KITTITAS COUNTY COMMUNITY DEVELOPMENT SERVICES

May 19, 2017

RE: Boundary Line Adjustment (BL-17-00006)

IOOF LODGE NO. 20 PROP.

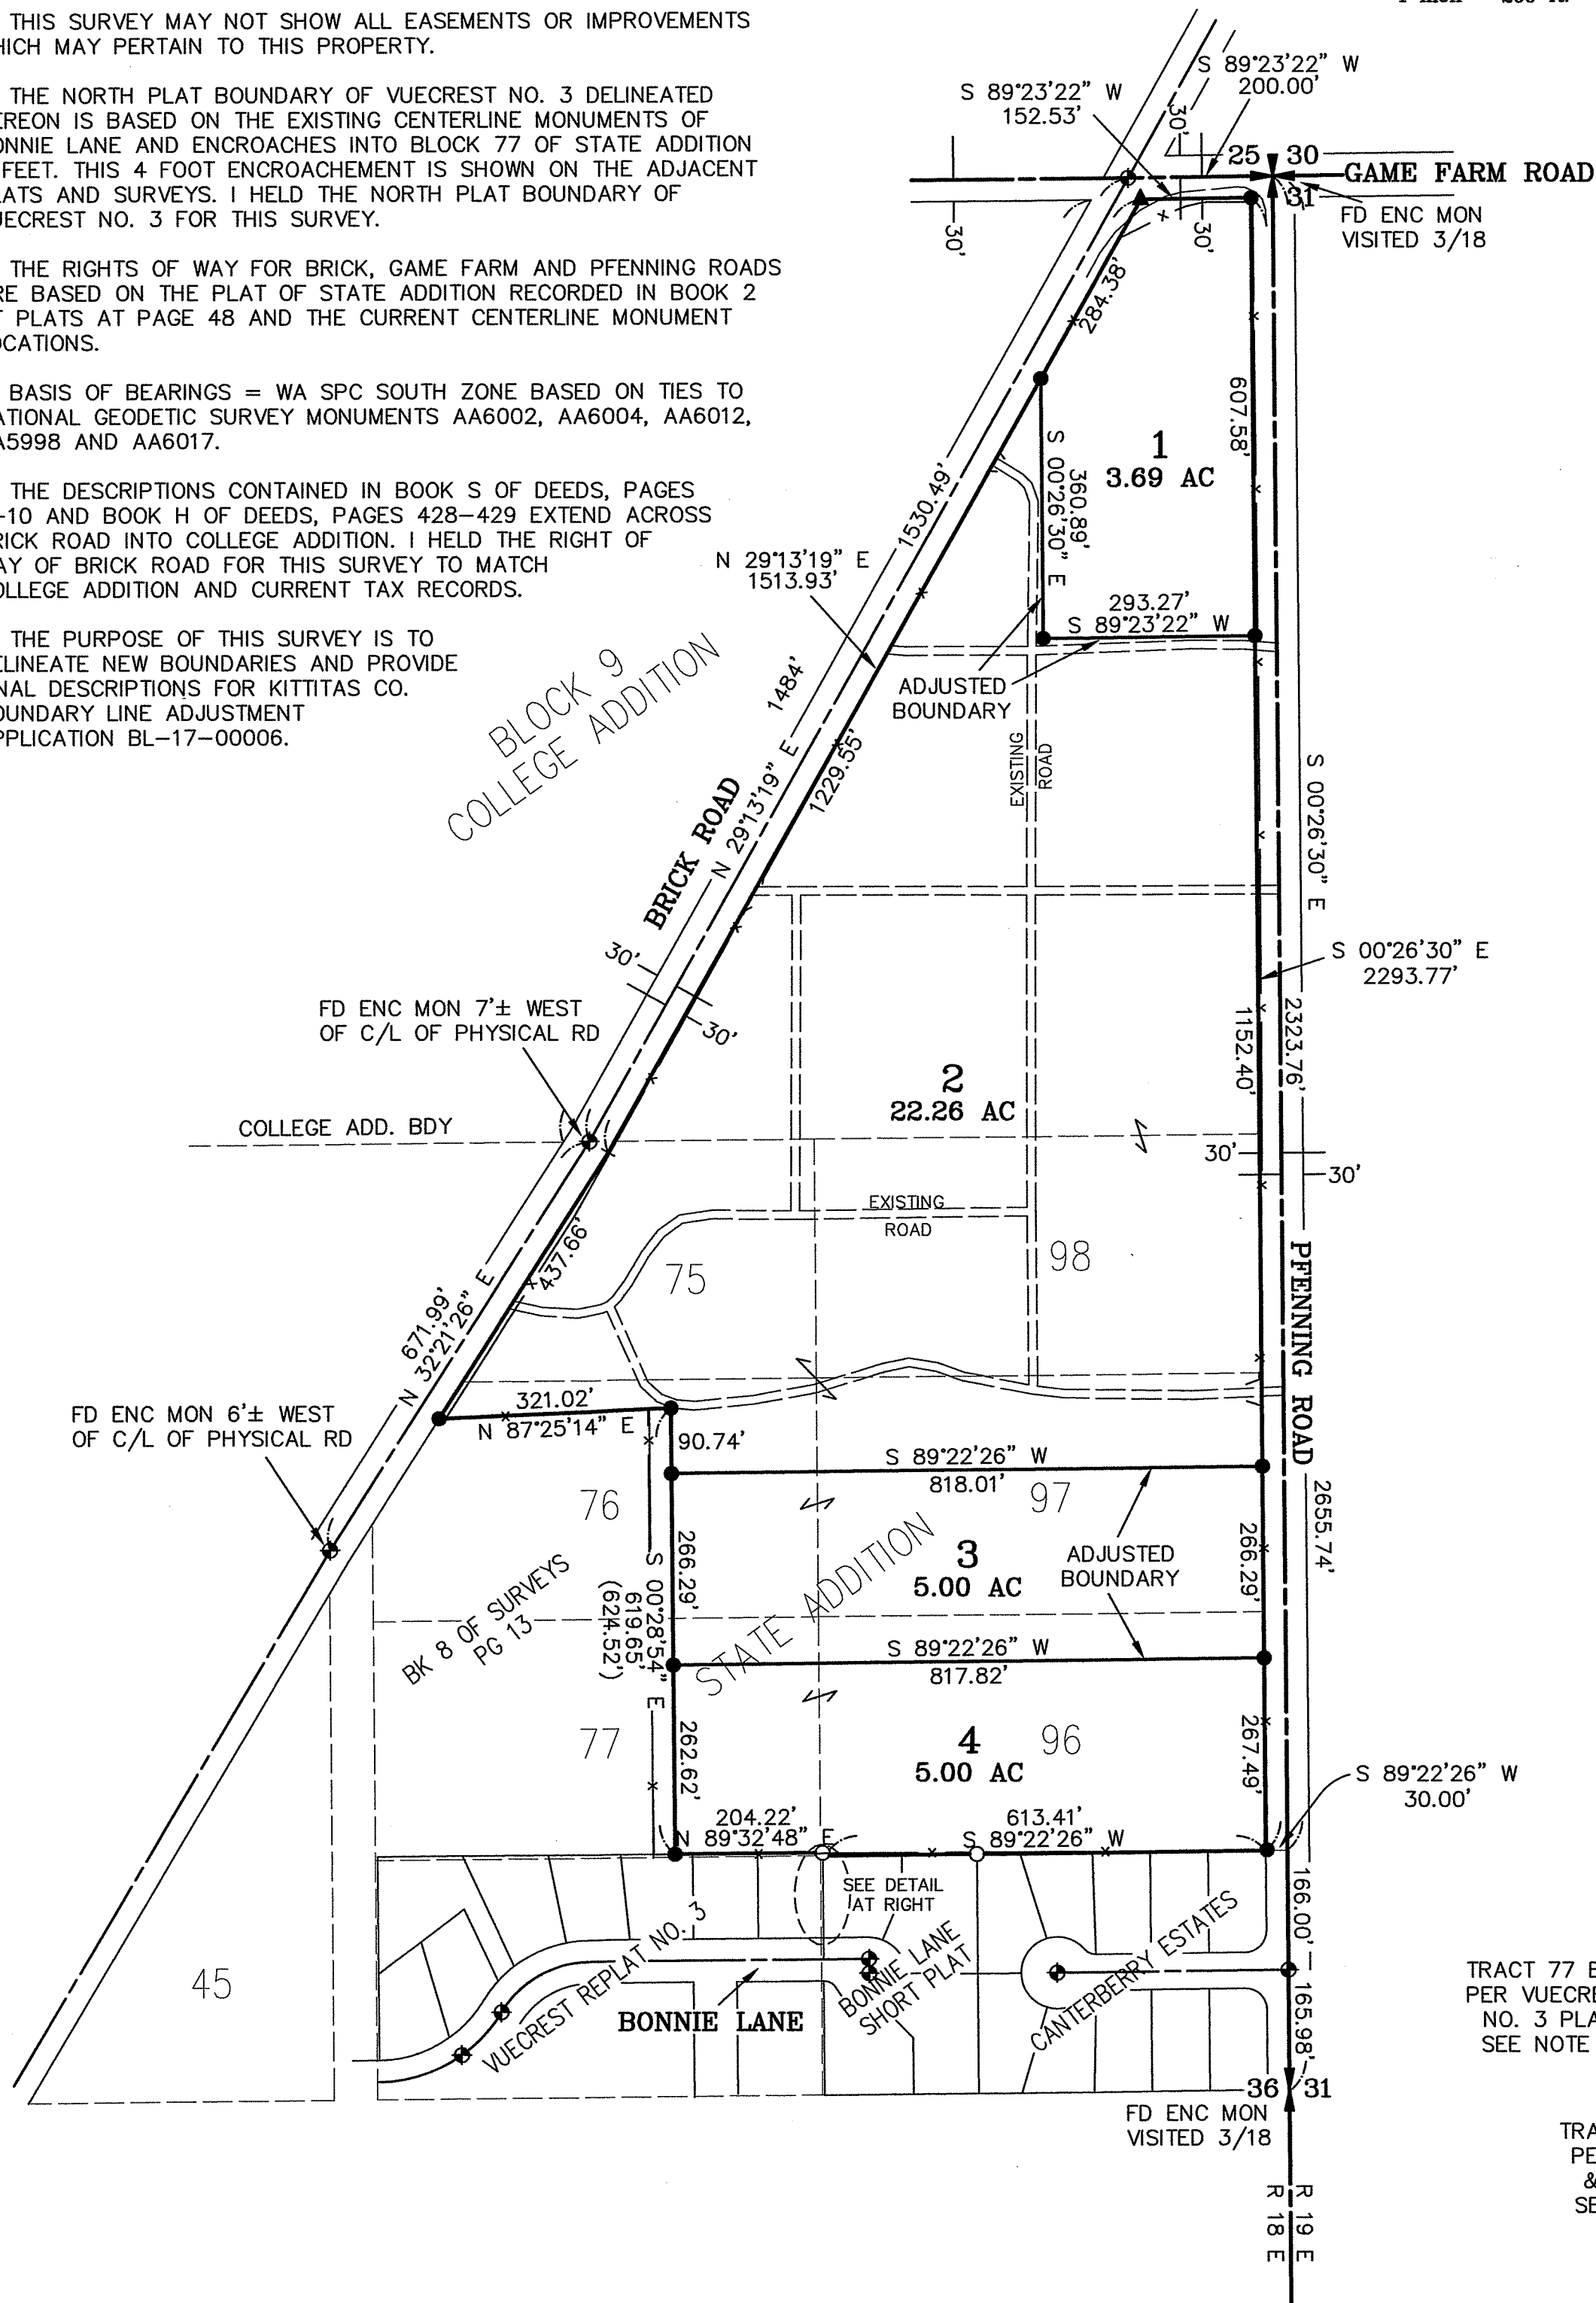
Kittitas County Community Development Services received a Boundary Line Adjustment permit on May 05, 2017. Please note that one of your existing parcels is located in the City of Ellensburg. Per County Code we are unable to create parcels that are multi-jurisdictional. An updated site plan and application are needed for this application to be processed.
